**Case Officer:** Samantha Taylor

**Applicant:** Bovis Homes Ltd

**Proposal:** Discharge of conditions 2 (natural stone sample), 9 (Estate roads, driveways etc), 16 (Biodiversity) and 17 (Bin collection points) of 15/01777/REM

DRAWING TITLE:
PARCEL D & E
S38 ADOPTION PLAN
SHEET 2 OF 2

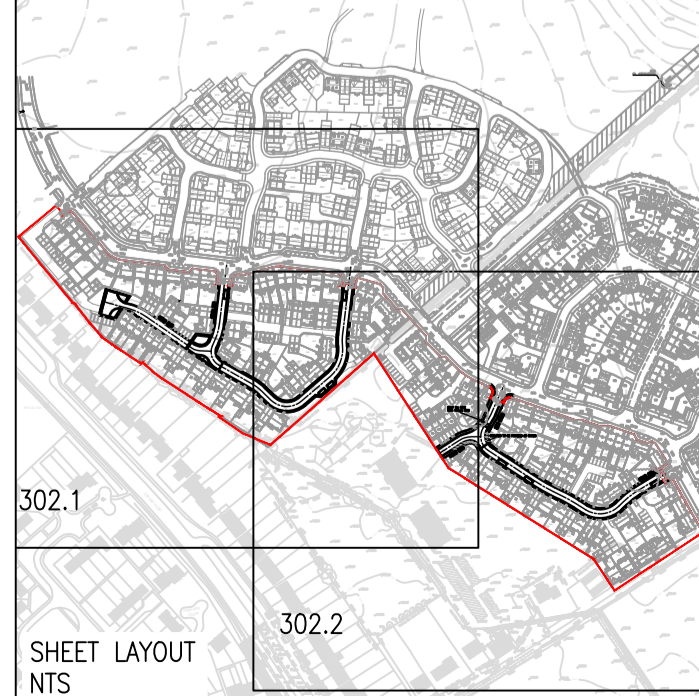
4.1. OCC HIGHWAYS – Condition 2 No comment, Condition 9 No objection as drawings match with approved S38 details

- 5.2. In respect of conditions 2, 9 and 17 the details as submitted are acceptable and satisfy the requirements of these conditions.
- 5.3. In respect of Condition 16, the Council's Ecologist has advised that the positions of the bird and bat boxes are not satisfactory as, for the sake of convenience, they appear to have been proposed on the remainder of dwellings to be constructed rather than in locations that would achieve an optimal biodiversity gain. However, the Local Plan policy ESD10 only requires a net gain; it does not currently specify a minimum. Furthermore, the Council's Ecologist, whilst expressing concerns, has not objected to the proposed locations.
